Response to Planning application from Hertfordshire County Council (T and CP GDP Order 2015)

District ref: 6/2022/0126/HOUSE
HCC ref: WH/11210/2022
HCC received: 28 February 2022
Area manager: Matthew Armstrong
Case officer: Steven Knight

41 THE RIDGEWAY CUFFLEY POTTERS BAR EN6 4BD

Dropped kerb to front of the property to create a carriage driveway.

Block Plan shows area bounded by: 528961.99, 203552.05 529051.99, 203642.05 (at a scale of 1:500), OSGridRef: TL2900 359. The representation of a road, track or path is no evidence of a right of way. The representation of features as lines is no evidence of a property boundary.

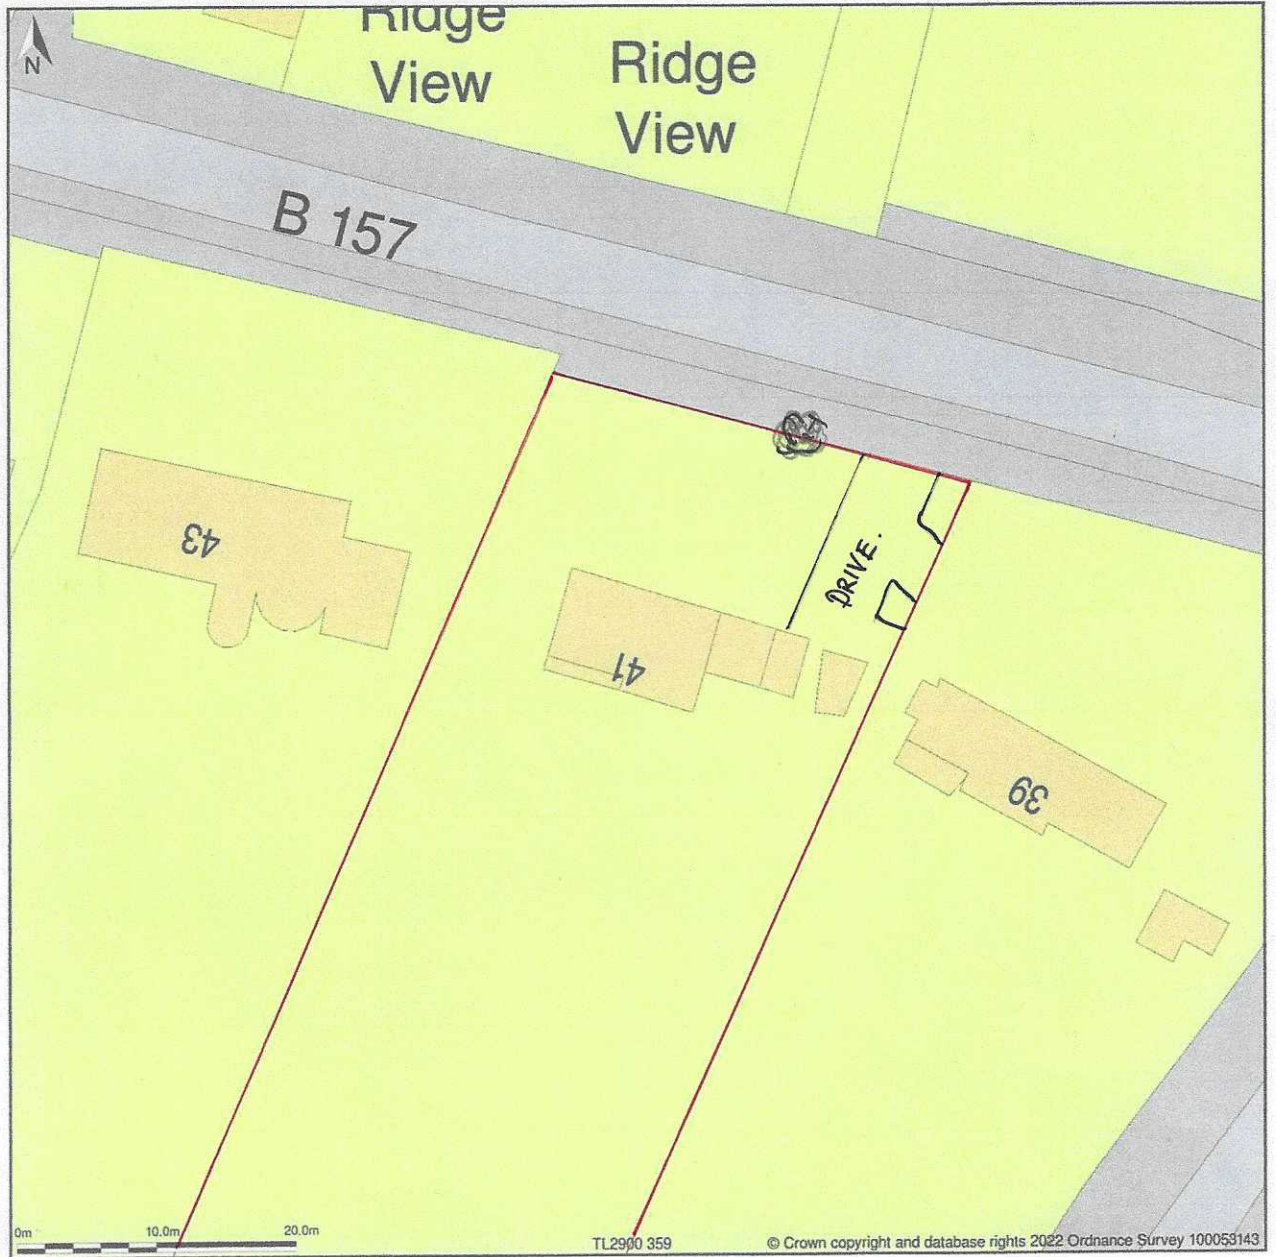
HCC's Dropped Kerb Terms and Conditions document states that each of the two vehicle crossings for a carriageway drive should consist of a maximum of 3 flat kerbs (2.7m). The proposed accesses are shown on the Block Plan at 5m although it is not clear whether these dimensions include the dropper kerbs or not. The applicant should ensure that the proposed vehicle crossings meet these criteria and that the driveway aligns with them. Any deviation could lead to the vehicle crossings being refused under S184 application.

Although the carriageway visibility splays are not shown on the Block Plan, the highway verge and footway provide the required 66m visibility splays. It is also accepted that one of the vehicle crossings is existing.

The Block Plan does show 2m x 2m footway visibility splays, which are acceptable. If these are not entirely achievable within the width of the highway verge then they may need to extend slightly inside the property boundary.

The drawing states that the proposed driveway will be finished with shingle. As per the informative above, some measures must be taken to prevent shingle from spilling onto the highway verge, footway or carriageway.

Prior to the first use of the development hereby permitted the vehicular access shall be completed and thereafter retained as shown on the 'Block Plan' in accordance with details/specifications to be submitted to and approved in writing by the Local Planning Authority in consultation with the highway authority. Prior to use appropriate arrangements shall be made for surface water to be intercepted and disposed of separately so that it does not discharge from or onto the highway carriageway. Reason: To ensure satisfactory access into the site and avoid carriage of extraneous material or surface water from or onto the highway in accordance with Policy 5 of Hertfordshire's Local Transport Plan (adopted 2018).
